PLAN REVIEW SHEET

Petition #: RZP 2022-205

Address: 7100 Mallard Creek Rd.

Request: R-8 MF (CD)

Rezoning Plan
Petition # 2022-205

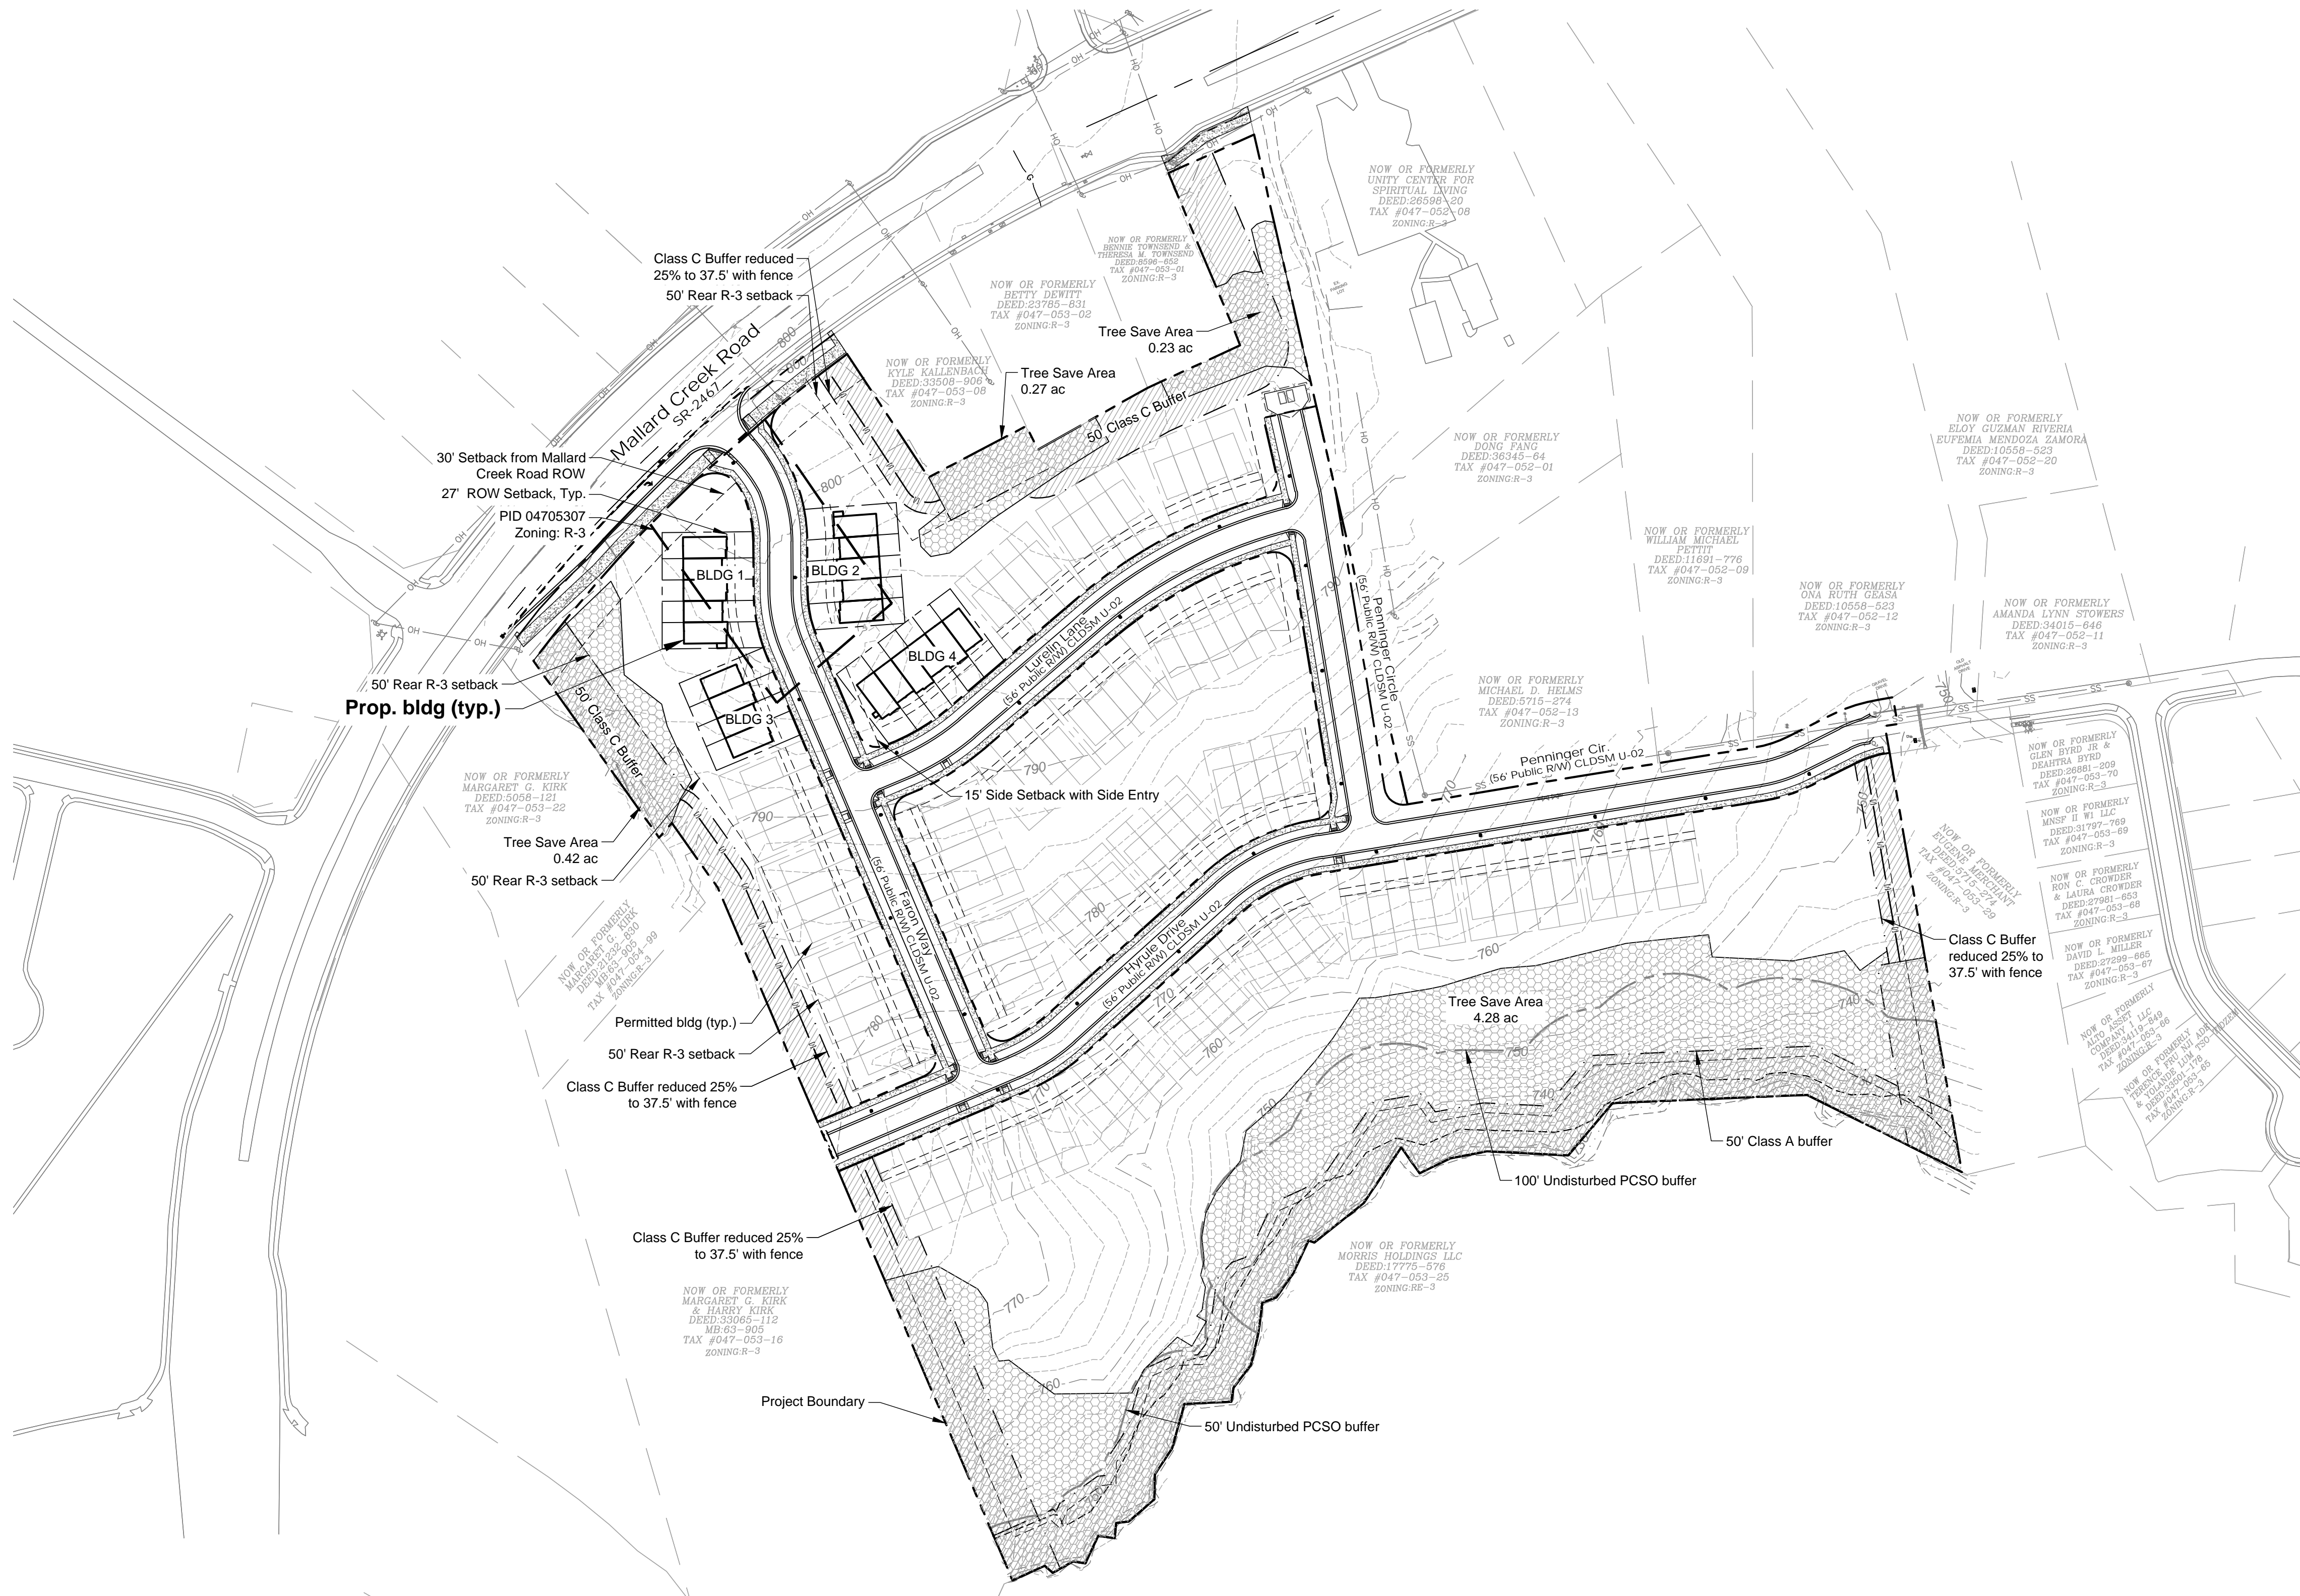
The site is located along CATS local bus route #22 on Mallard Creek Road. CATS requests the construction of ADA compliant bus standard detail 60.02A on Mallard Creek Road. The final location will be coordinated with the developer during the Land Development plan review process.
